North Lincolnshire Council answers to the Examining Authority's further written questions (24 October 2019) for the VPI Immingham OCGT Project

Question 2.4.1 – Operational Noise

Please comment on the proposed revisions to R19 of the revised dDCO [REP3-003] in relation to operational noise.

Drawing Title
BASELINE NOISE MONITORING LOCATIONS AND SENSITIVE RECEPTORS FIGURE 8.1

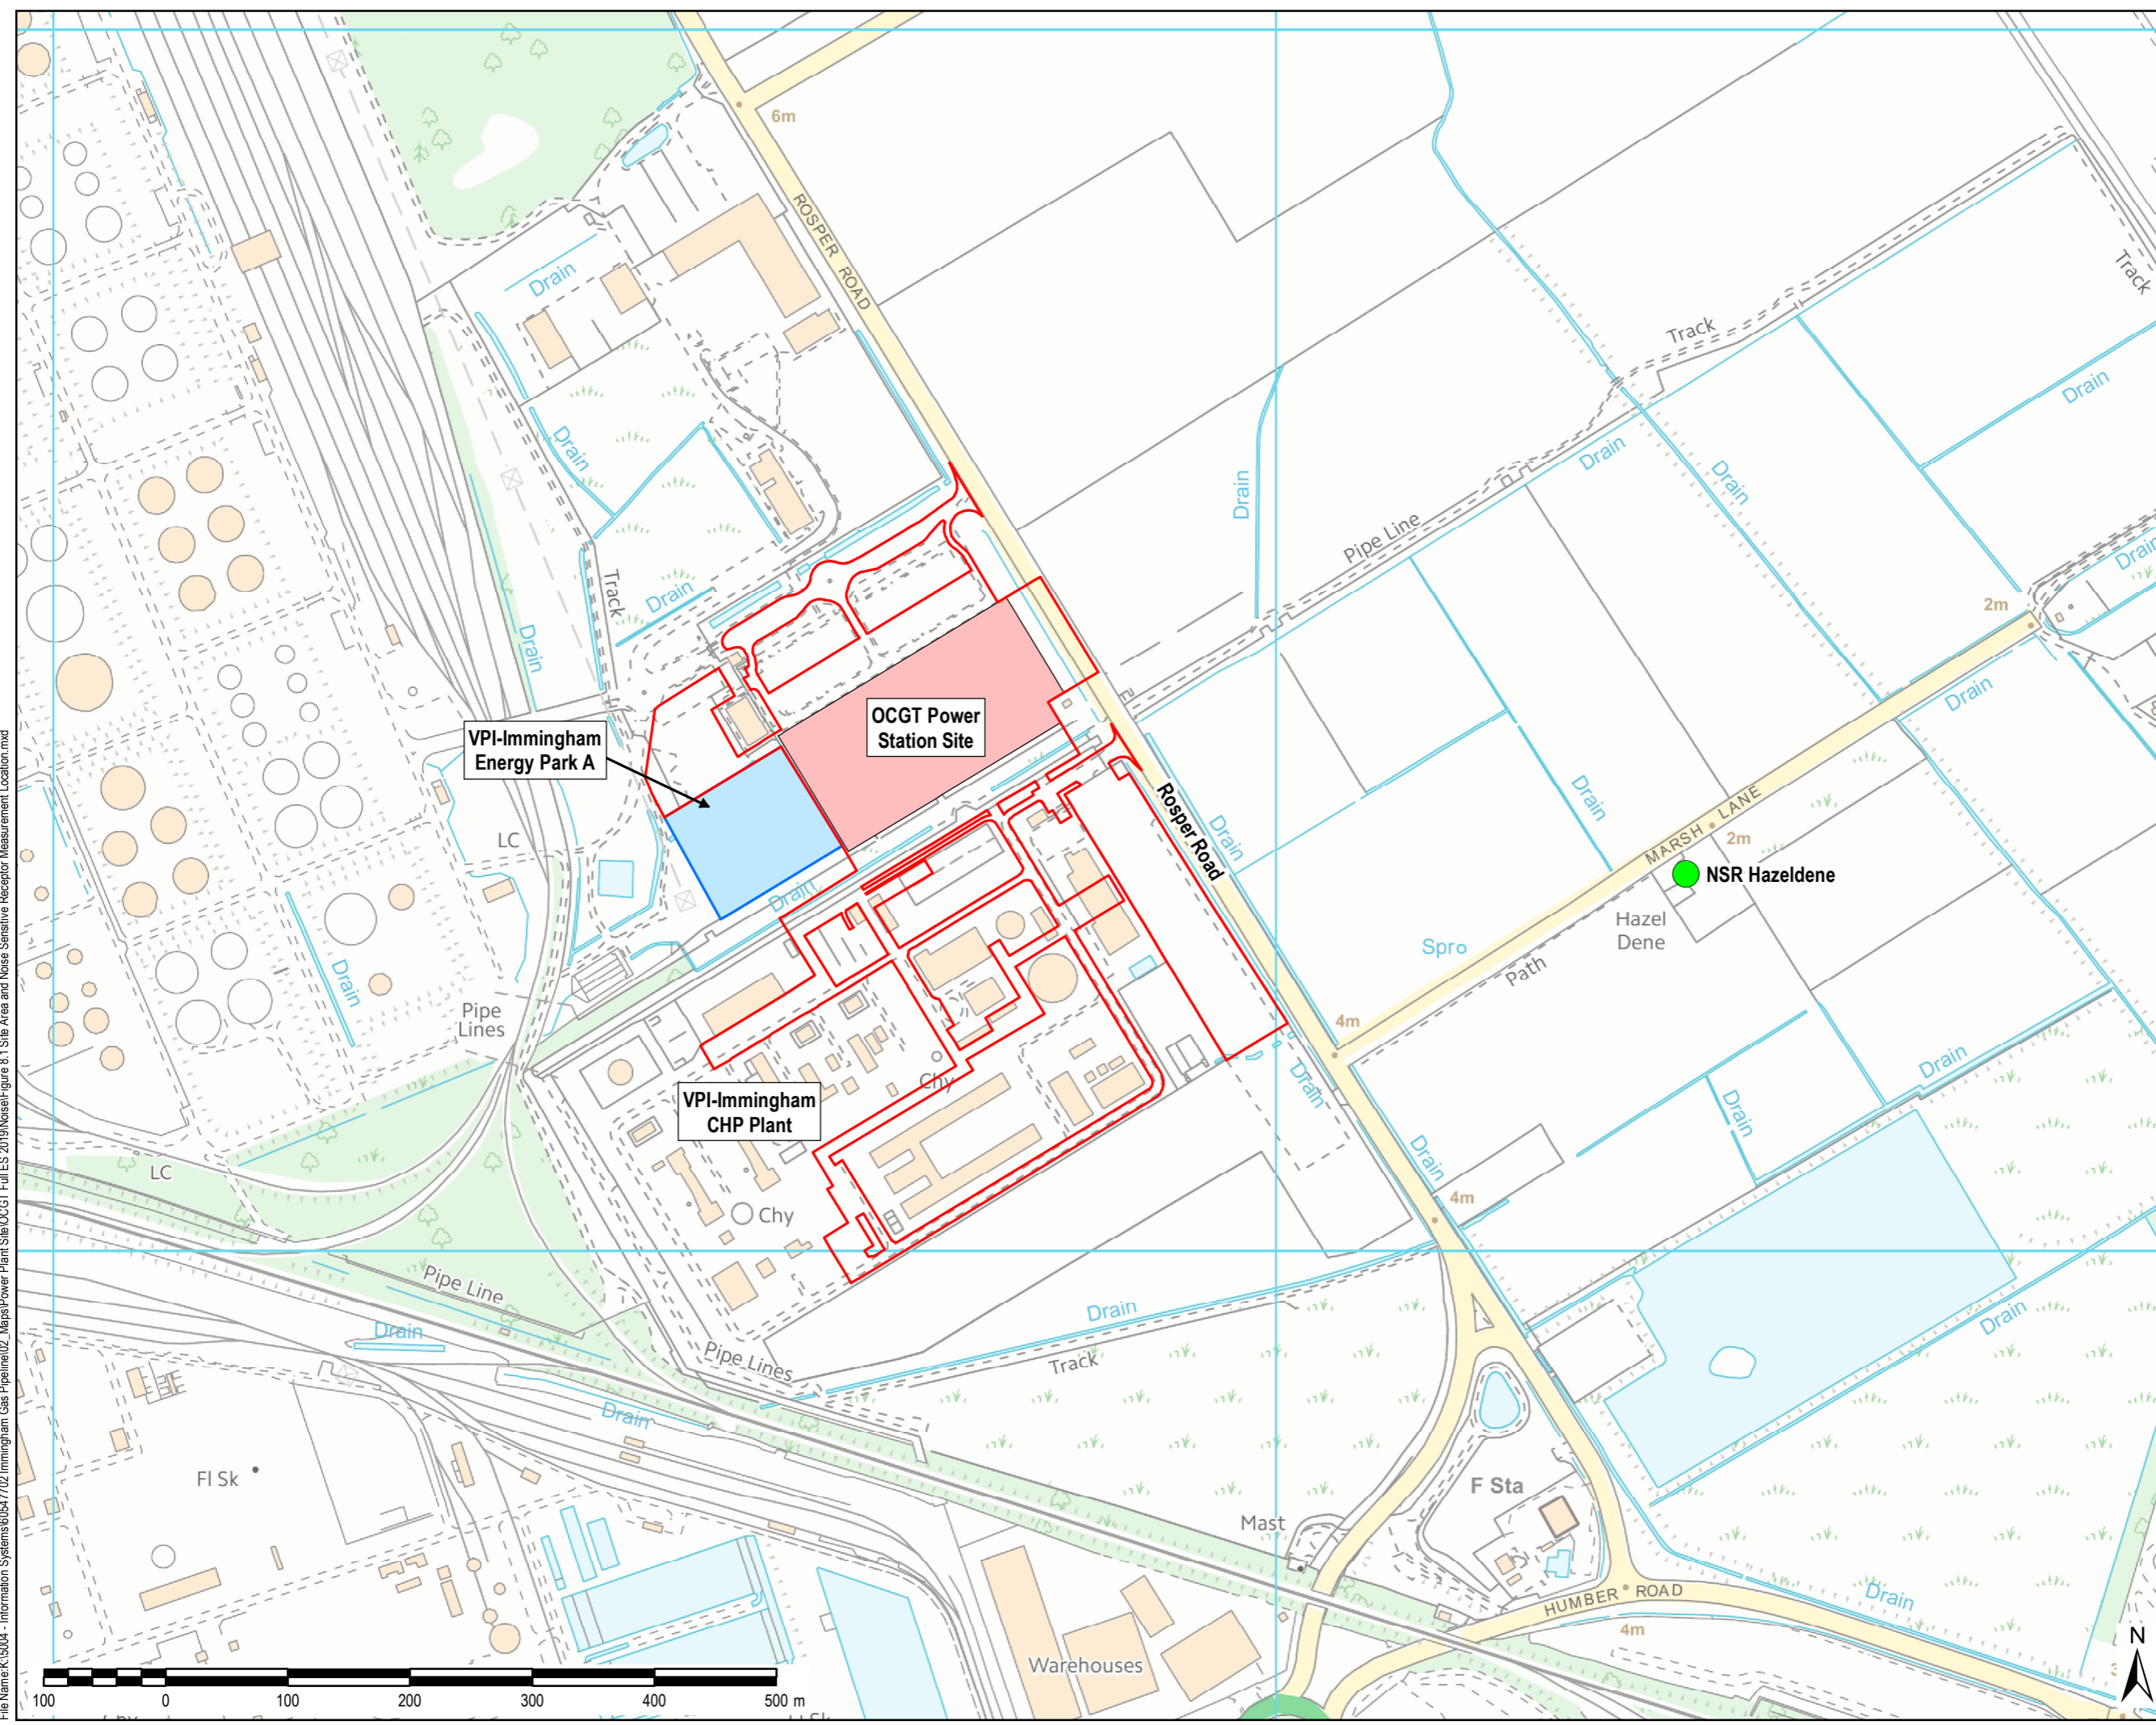
Figures provided in Table 8.16 of Chapter 8 (Noise and Vibration) of the submitted Environmental Statement demonstrate that operational noise levels of 1dB above background as a rating level at the nearest residential receptor can be achieved. Therefore NLC are unsure why a limit of +5dB above background is required.

NLC is of the opinion that as background levels are already high in the area, allowing an additional +5dB will result in unacceptably high noise levels for the nearest resident, particularly during the night time hours.

Night-time noise levels in the area are already high with background at 49dB LA90 and ambient at 53 dB LAeq. To allow a 5dB increase in background will allow unacceptable noise levels at the nearest residential receptor and allow background levels to creep up in the area. The closest residential receptor is approximately 650m to the east of the proposed development, allowing +5dB would therefore allow the power station to raise background across a considerable area.

It is further noted that the World Health Organisation (WHO) recommend 45 dB LAeq outside bedroom windows to avoid sleep disturbance. Ambient noise levels are already higher than this in the area at 53 dB LAeq. Allowing background levels to increase by 5dB will raise ambient levels even further resulting in a detrimental effect on the resident.

NLC maintain the opinion that the operational noise limit should be set at 3dB above background and that the application documents demonstrate that this noise limit would be achievable. For the reasons outlined above it is considered that the amended Requirement 19 is not sufficient to protect the amenity of the nearest receptor. The requirement for the applicant to explore the possibility of achieving a lower noise level does not give any assurance that a lower level will be achieved and could potentially result in further disagreement at the discharge of requirement stage.
